CITY OF ALBUQUERQUE

October 18, 2021

**Re: Ellison St. Office Warehouse
4000 Ellison St NE
Traffic Circulation Layout
Architect's Stamp 10-13-2021 (D17-D074)**

SHEET
T.1

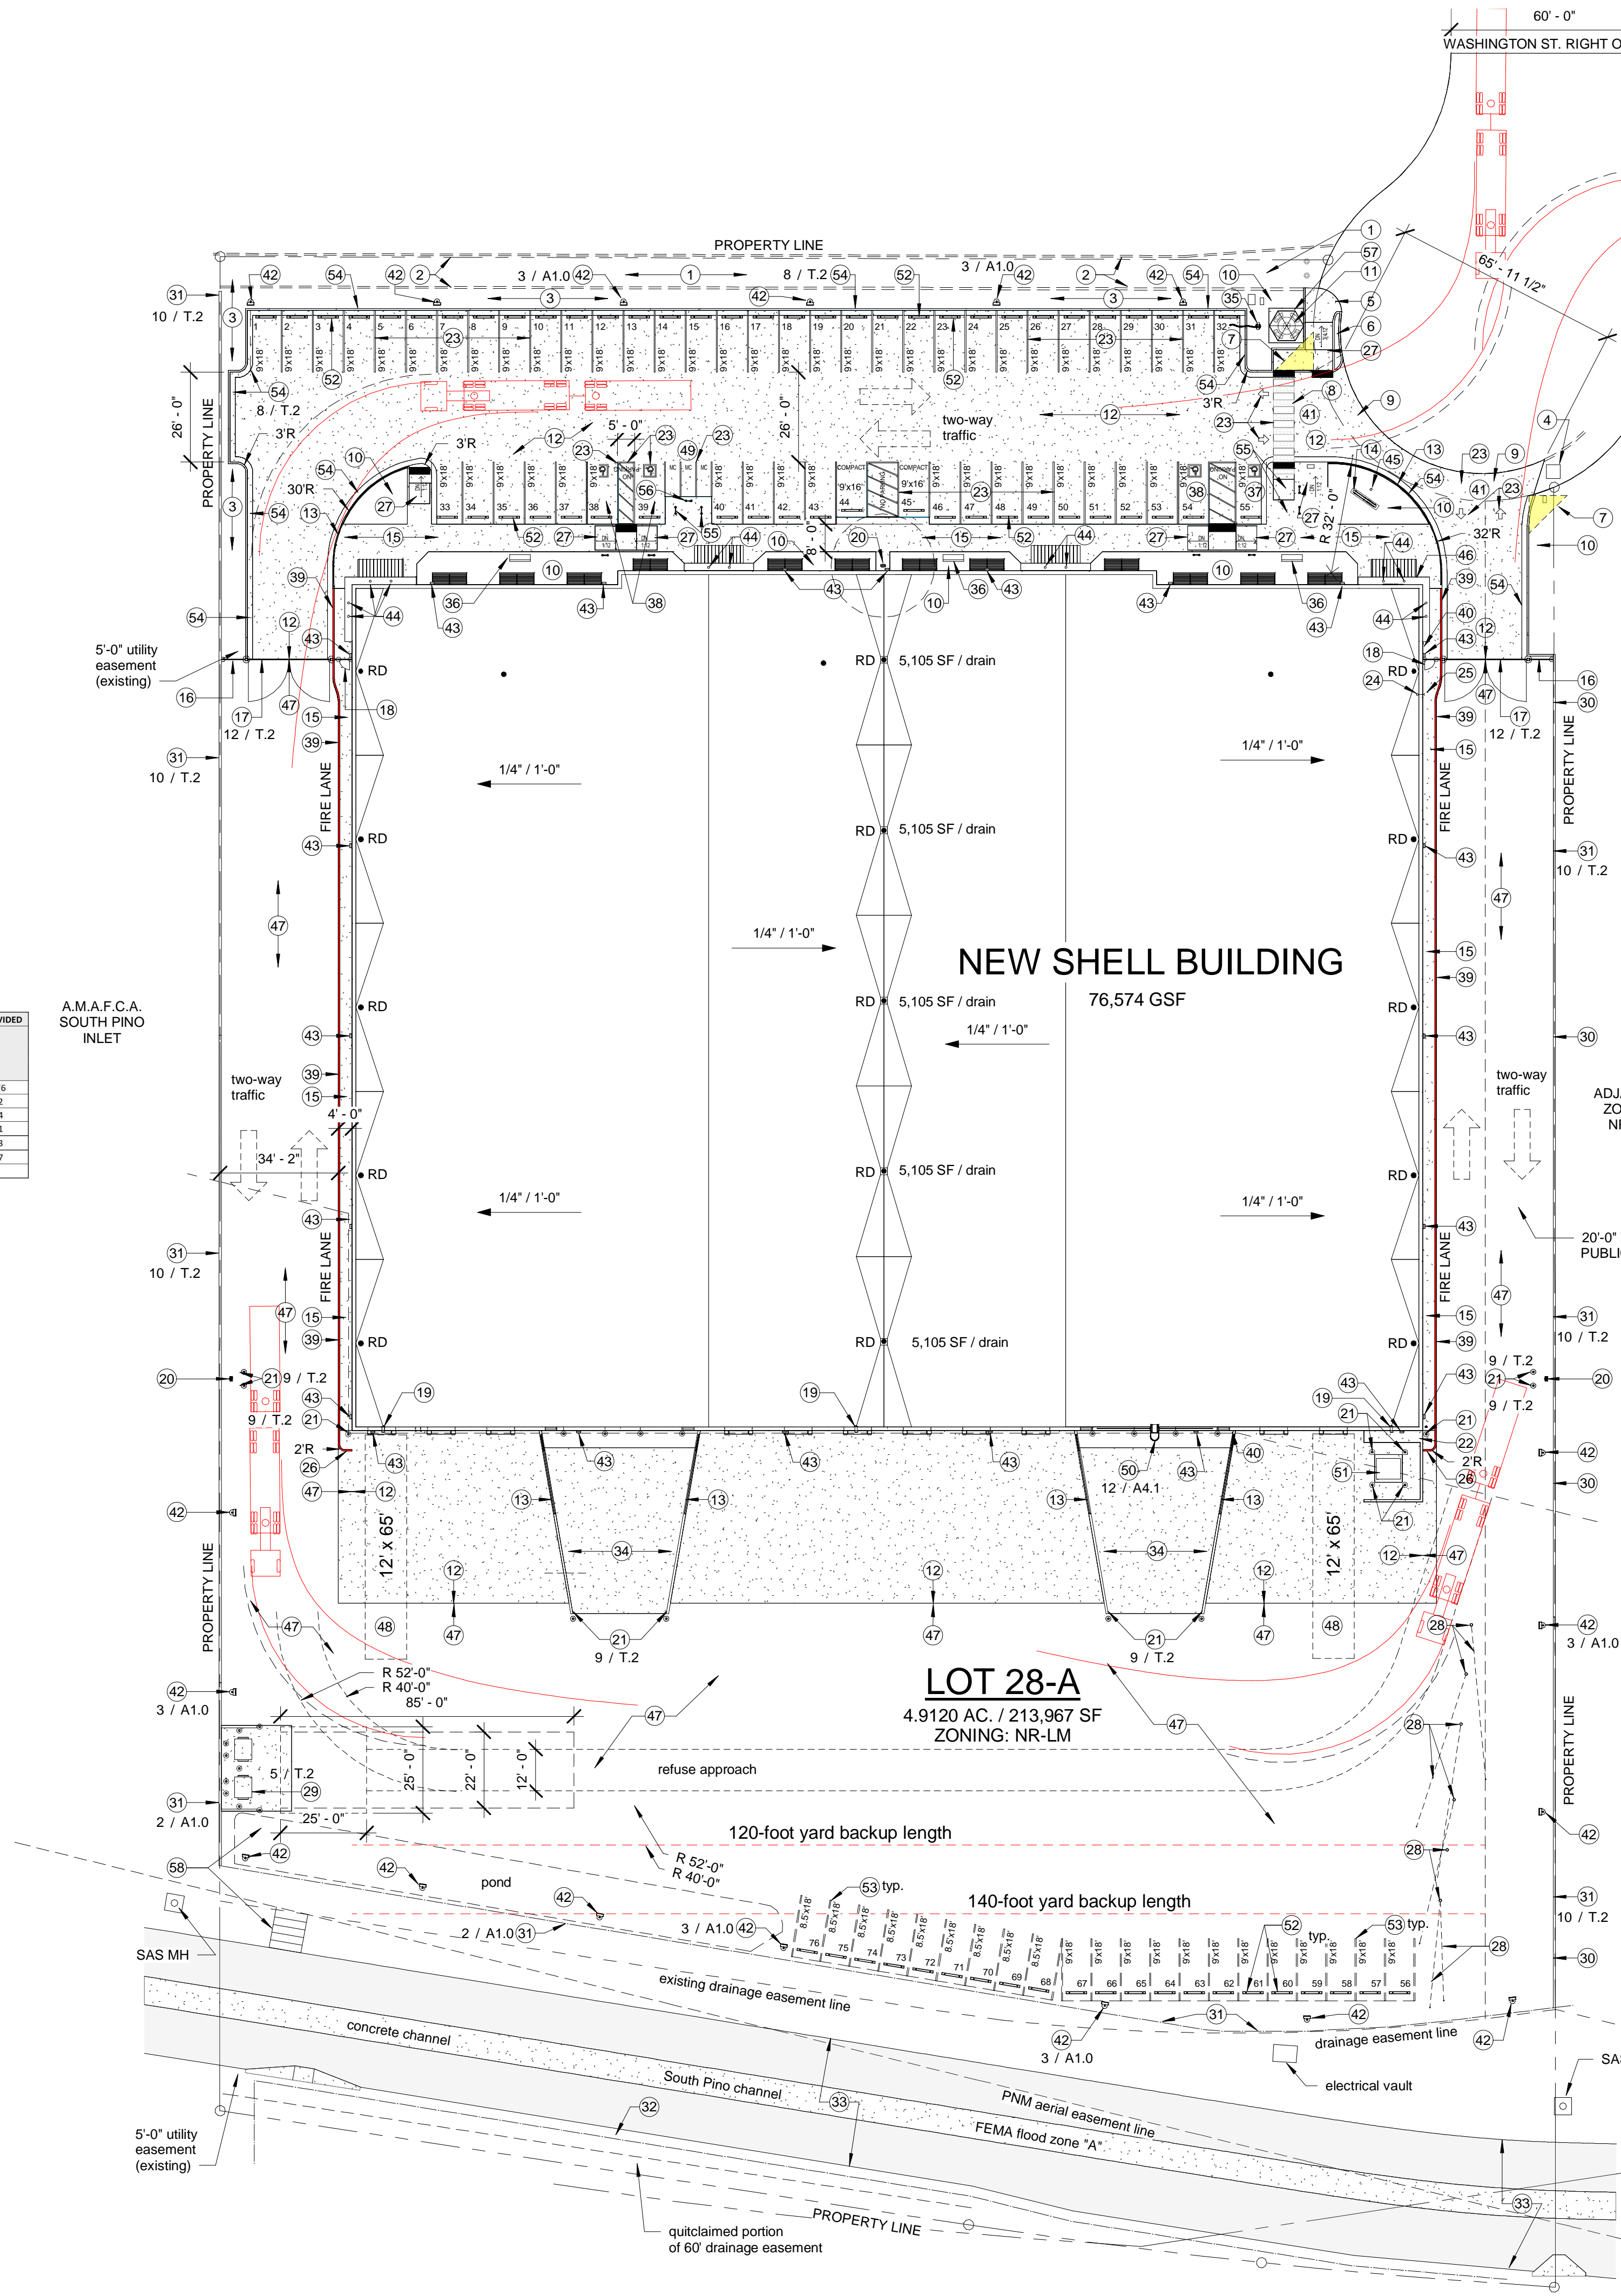
1. **PLEASE RE REVIEW ALL CHANGED KEYED NOTES TO ITEMS BEING SPECIFIED VERSUS WHERE ARROWS ARE POINTING TO BECAUSE THEY ARE NOT CORRECTING BEING REPRESENTED.**

2. **Concrete Drainway Ellison Frontage (prior comment not properly addressed):**
 - A Detail will need to be provided to show that ADA is in compliant across concrete drainway.

- The ADA ramp needs to service across the entrance on public Row and on private property (Key Note 26).
 - So I suggest you provide a ramp design that will service private property and public ROW.

- **ADA slopes for ramp is 12:1 max.** Please adjust details sheet.
 - **Proposed Apron: Details will need to be provided (concrete design, dimension ect...)**

3. **Eastern entrance frontage:** Please apron transition to existing curb and gutter.
4. **Keyed Note 8:** Provide reference note for proposed detail on **sheet T.2.**

5. **Keyed Note 11:** Specifies outdoor table but arrow is pointing to pavement and gate. Please clarify.
6. **Keyed Note 13:** Specifies Monument Sign but arrow is pointing to curb & gutter. Please clarify.

7. **Keyed Note 14:** Specifies concrete sidewalk but arrow is pointing to monument sign. Please clarify.

8. **Keyed Note 15:** Specifies 6'-6" high steel fence but arrow is pointing to what appears to be concrete sidewalk.
9. **Keyed Note 27:** Specifies existing power poles but arrow is pointing to curbing o site. Please clarify.

10. **Keyed Note 41:** Specifies Light pole but arrow is pointing to pavement marking arrow at entrance. Please clarify.
11. Proposed ADA curb ramp (**Keyed Note 26**) **Prior comment not addressed:**

- Details will need to be provided for on-site and driveway entrance (**Apron**).
 - It appears the proposed ramp is in conflict with drive way entrance and a detail will need to be provide to demonstrate ADA accessible across this driveway/pad to ensure ADA access is compliant across the entrance.

- In order for driveway to be ADA compliant, you will need adjacent property owner permission to construct a ramp on the east leg of driveway.
 - This proposed/private ADA ramp will need to be located on private property.

12. **Motorcycle parking spaces:** Label pavement MC. The signage is not being referenced. Keyed note 56 points to signage but note specifies concrete sidewalk.
